# Rezoning Transportation Analysis

Petition Number: 2020-072

General Location Identifier Tax ID 071050104

Date	Description
07-22-20	First Review
08-26-20	Second Review

RZ-1

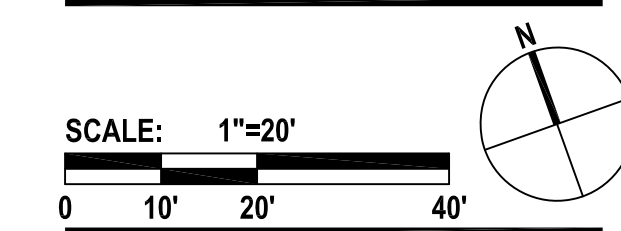
6. **New Comment (site plan dated 8-17-20)** The petitioner should revise the site plan right-of-way dedication and to add a note specifying dedication of additional right-of-way of sidewalk utility easement to accommodate a future 12-ft multi-use path, in accordance with Charlotte BIKES. CDOT apologizes for not including this comment within the first review memo.
